Project Title: kirkpatrick	Building Permit #:	City Drainage #: C17D122	
DRB#: EPC#:		Work Order#:	
Legal Description: B1A5 CLIFFORD INDUSTRIAL PARK			
City Address: 8610 presidents place			
Engineering Firm, RIO GRANDE ENGINEERING		Contact: DAVID SOULE	
Address: PO BOX 93924 AI BUOUEROUE NM 87199			
Phone#: 505.321.9099		E-mail: DAVID@RIOGRANDEENGINEERING COM	
Owner: KIRKPATRICK COMPANY		Contact:	
Address:			
Phone#: Fax#:		E-mail:	
Architect: DAN HERR		Contact:	
Address:			
Phone#: Fax#:		E-mail:	
Surveyor: CONSTRUCTION SURVEY INCORPORATED		Contact: JOHN GALLEGOS	
Address:		E moite	
Phone#: 917.8921 Pax#:		E-mail:	
Contractor:		Contact:	
Address:			
Phone#: Fax#:		E-mail:	
TVPF OF SURMITTAL .	CHECK TVPF OF APPROV	AT /ACCEPTANCE SOUCHT.	
DRAINAGE REPORT	SIA/FINANCIAL GUARAN	SIA/FINANCIAL GUARANTEE RELEASE	
DRAINAGE PLAN 1st SUBMITTAL	PRELIMINARY PLAT APP	PRELIMINARY PLAT APPROVAL	
× DRAINAGE PLAN RESUBMITTAL	S. DEV. PLAN FOR SUB'D	S. DEV. PLAN FOR SUB'D APPROVAL

RE: Revised Grading Plan (C-17D122) Kirkpatrick Warehouse Albuquerque, New Mexico

Re: Kirkpatrick Warehouse Kirkpatrick Warehouse Drainage Report dated 11-25-14 Kirkpatrick Grading and Drainage Plan with Engineer's Stamp

ENGINEER'S SEAL 	TRACT B-1-A-5 CLIFFORD INDUSTRIAL PARK	DRAWN BY JDG
	GRADING AND DRAINAGE PLAN	DATE 11-26-2014
		SHEET # 1 OF 1
12/22/14 DAVID SOULE P.E. #14522	1606 CENTRAL AVENUE SE SUITE 201 ALBUQUERQUE, NM 87106 (505) 872-0999	JOB #

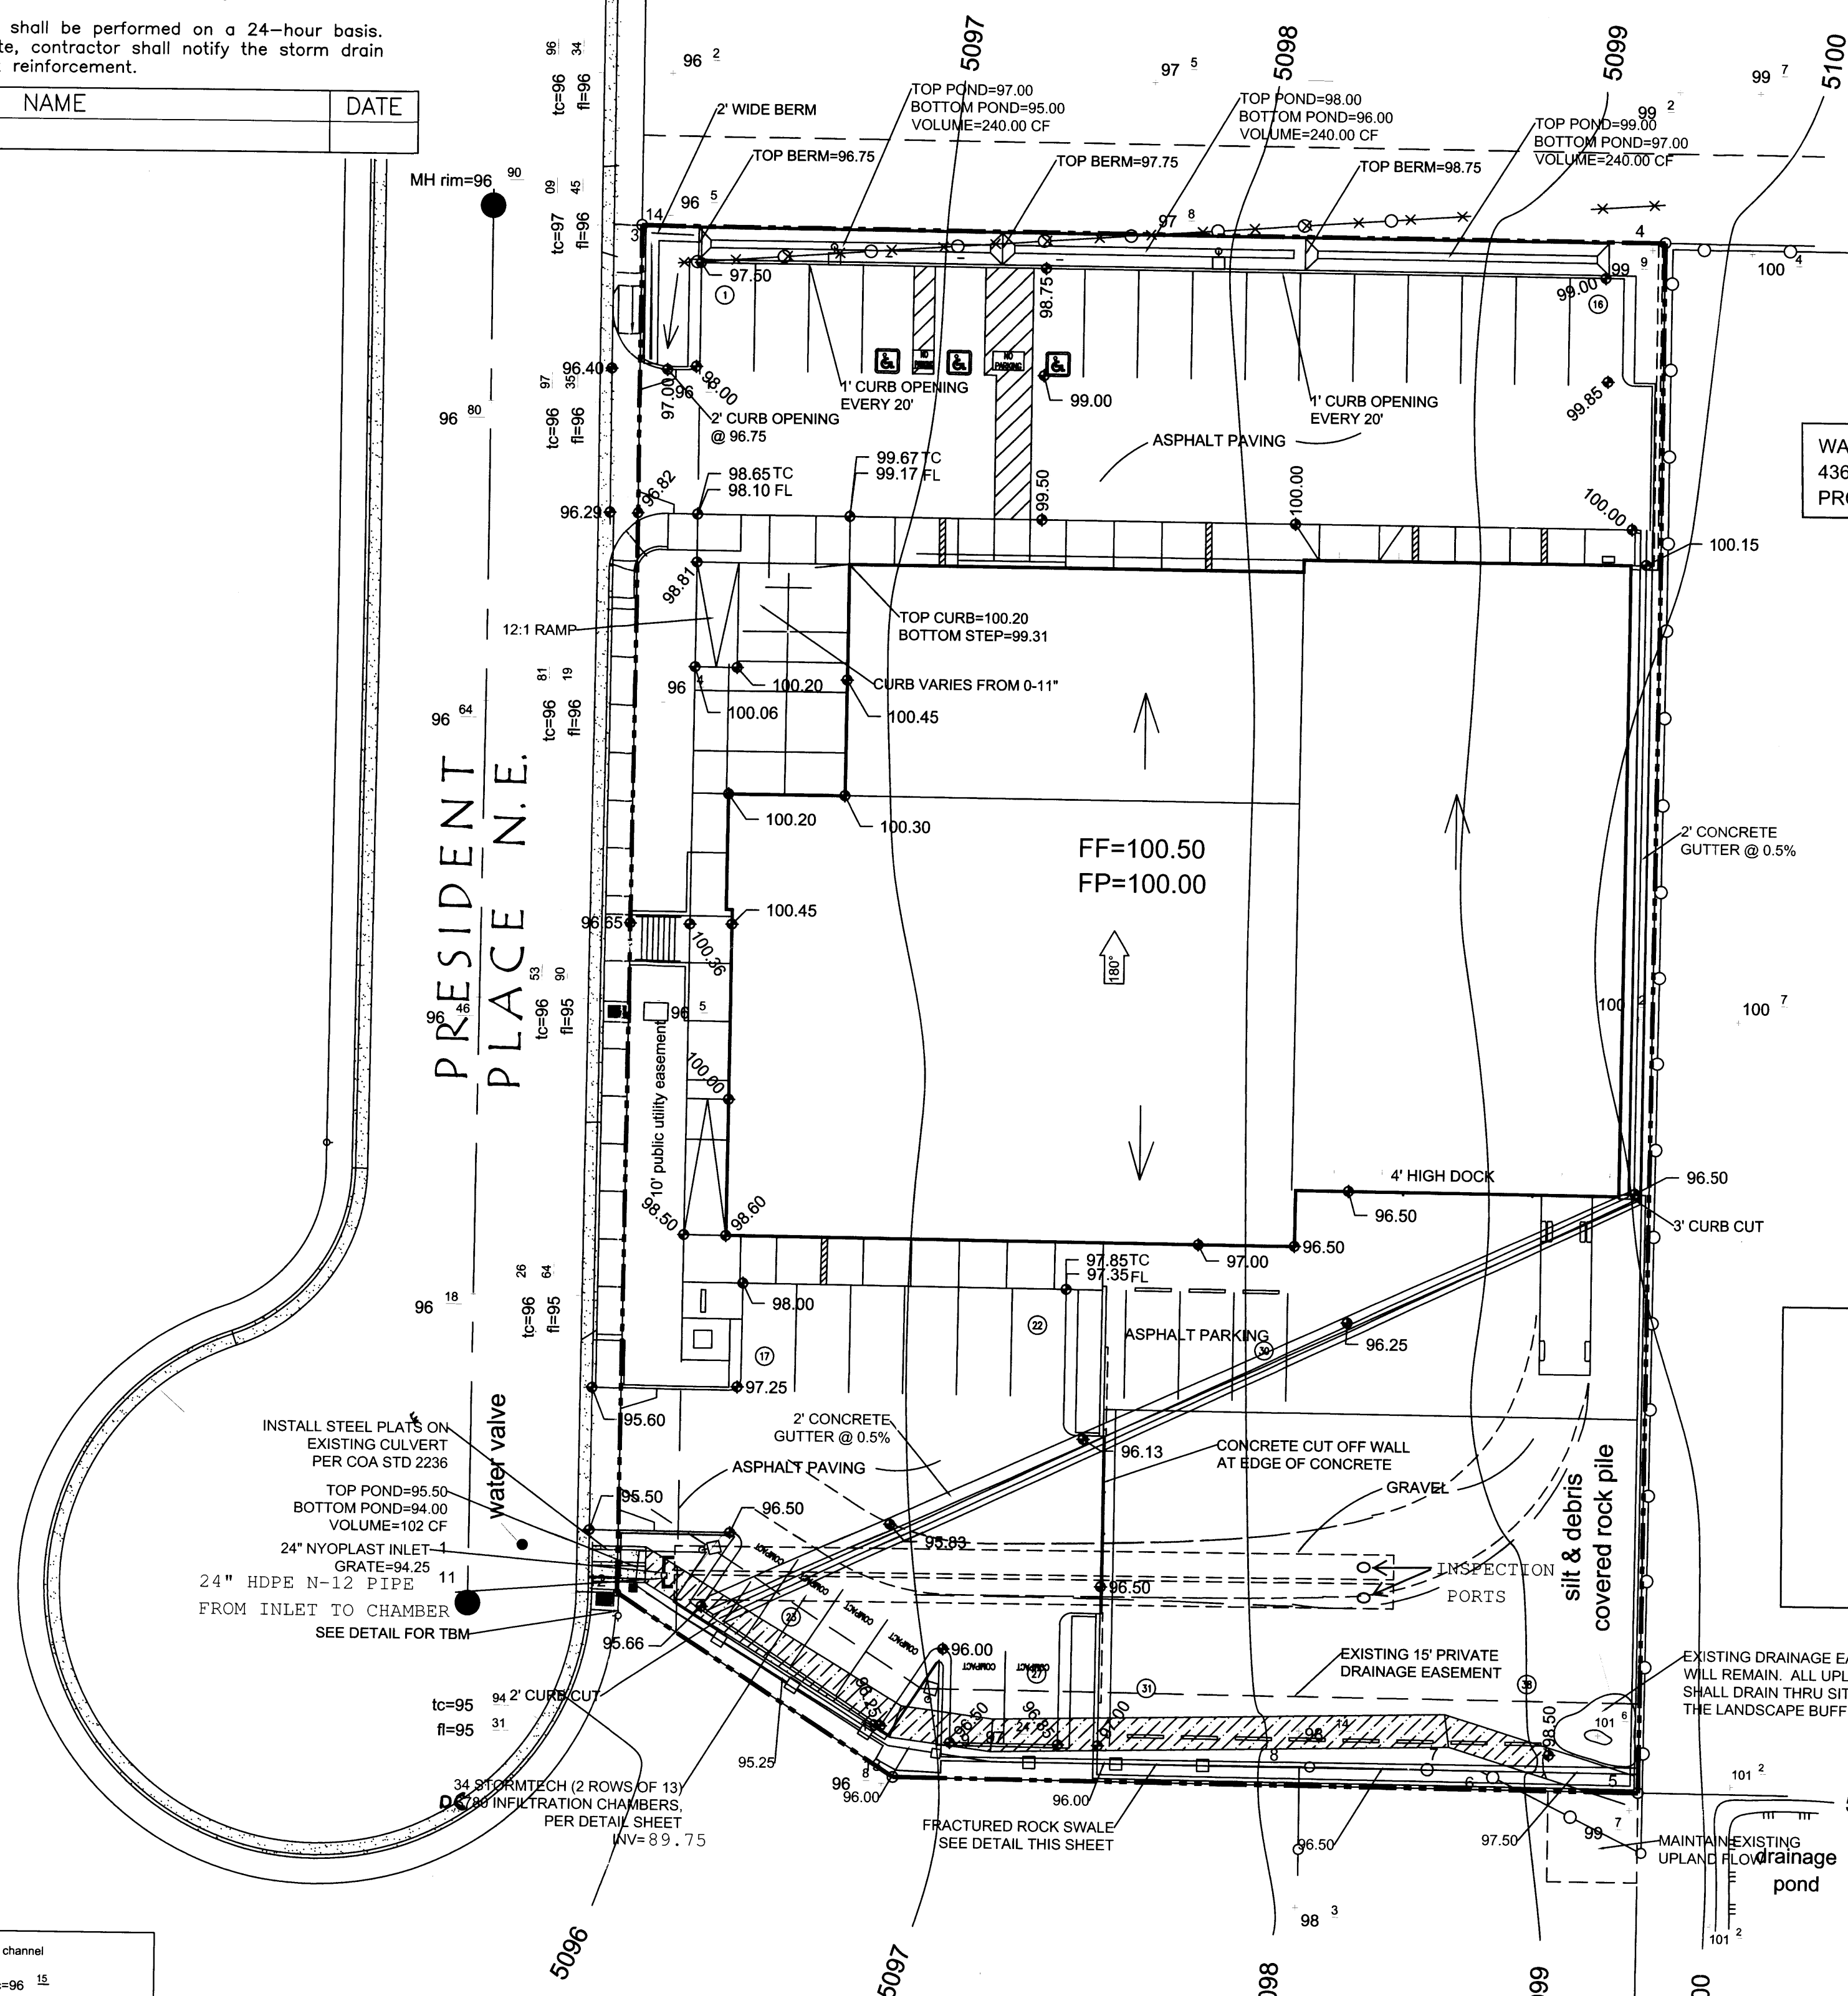
- 1. Provide a steel plate for the existing culvert draining to the curb per City Standard Drawing 2236 with modified detail B-B. Since this will require work in the ROW, include a SO-19 request and SO-19 language on the plan.
- 2. Add a valley gutter detail to the plan.

- Call out a curb opening where the storm water drains from the valley gutter to the pond inlet.
- 4. For the First Flush, you only need to multiply 0.34 inches times the impervious area of the site not the entire area of the site.

- Provide steel plate on culvert.
 We have added the note and SO19 to the plan. The existing culvert extends approximately 5' past the property line
- Add valley gutter detail to plans
 We have added the detail
- 3. Call out curb opening at pond.

We have labeled the opening, and have attached the calculation to demonstrate 2' is adequate for the 1.77 cfs

The volume retained for this site is governed by the need to reduce flow of the site. The required volume exceeds the volume required for the first flush. We have noted the clarified city requirement and will utilize this amount in all future plans
